August 16, 2005

**Subject: Application for a Permit Modification for Section 404 and 401 permits For the improvements to SR 1400 (Cliffdale Road) from US 401 to SR 1403 (Reilly Road), Cumberland County. TIP No. U-2520; Federal Aid No. STP-1400(2); State Project No. 8.2441701; USACE Action ID 200200640; DWQ Project No. 020400. \$475 to WBS No. 34818.1.1**

**Permit Drawing 9 of 11/Site 4**

STEP POOL DETAIL

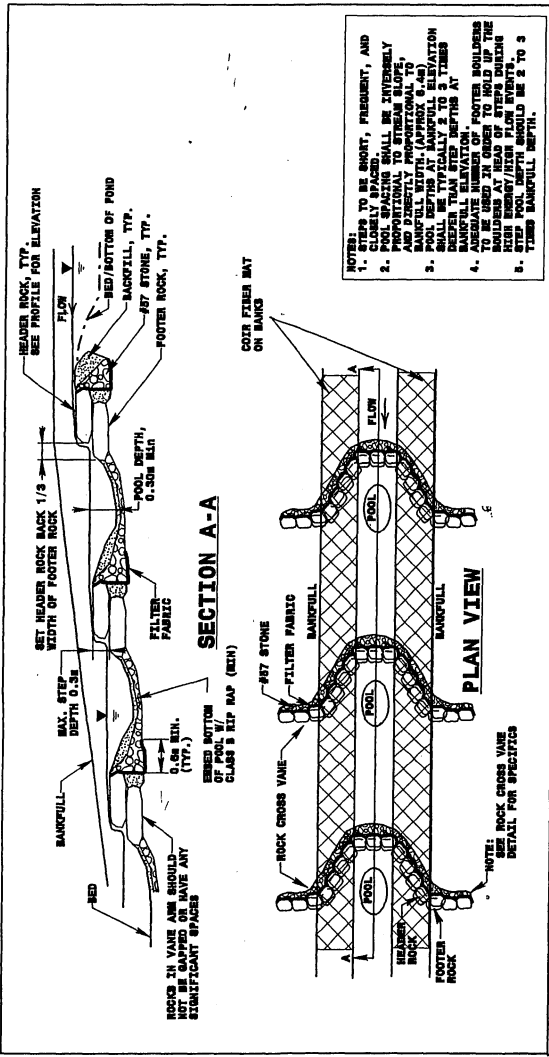
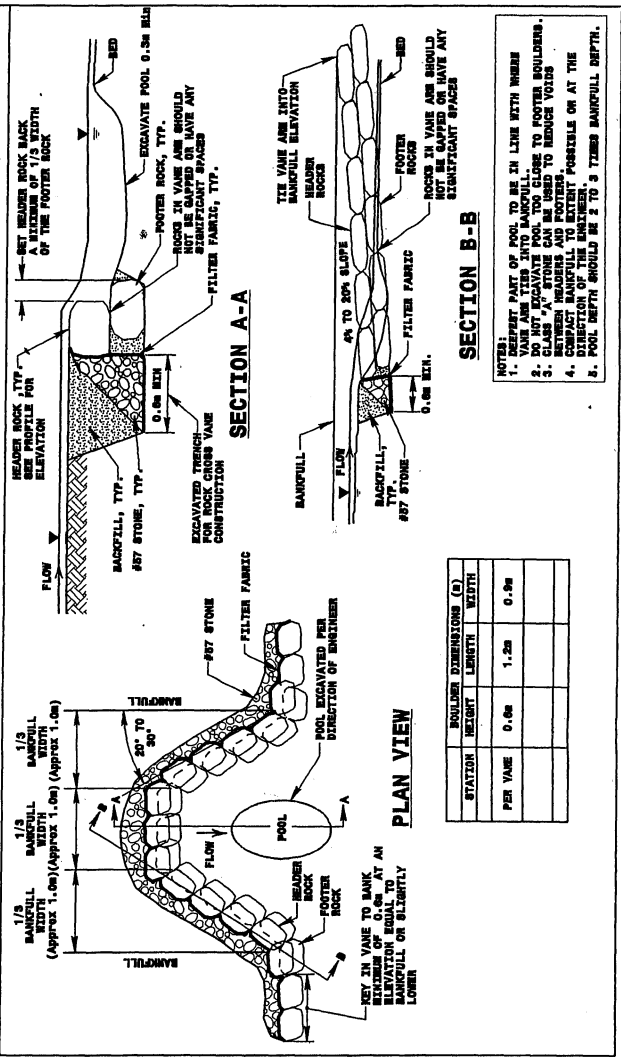
The stream at this site was not shown correctly on the plans and so at the inlet of this culvert, the stream is eroding, scouring and headcutting upstream. To control the erosion and provide stability for this stream a step pool is designed at the inlet. The step pool is 58 ft and the design is enclosed with this application.

At the outlet of this culvert a rip rap pad with an energy dissipator basin is needed to dissipate the water coming out of the culvert.

A preformed scour hole was changed to a energy dissipator basin near this site for the same reason as above. .

The additional impacts to both of these areas at Site 4 are 95 ft. This stream is intermittent and did not require mitigation in the original permit so no mitigation is required for these additional impacts.
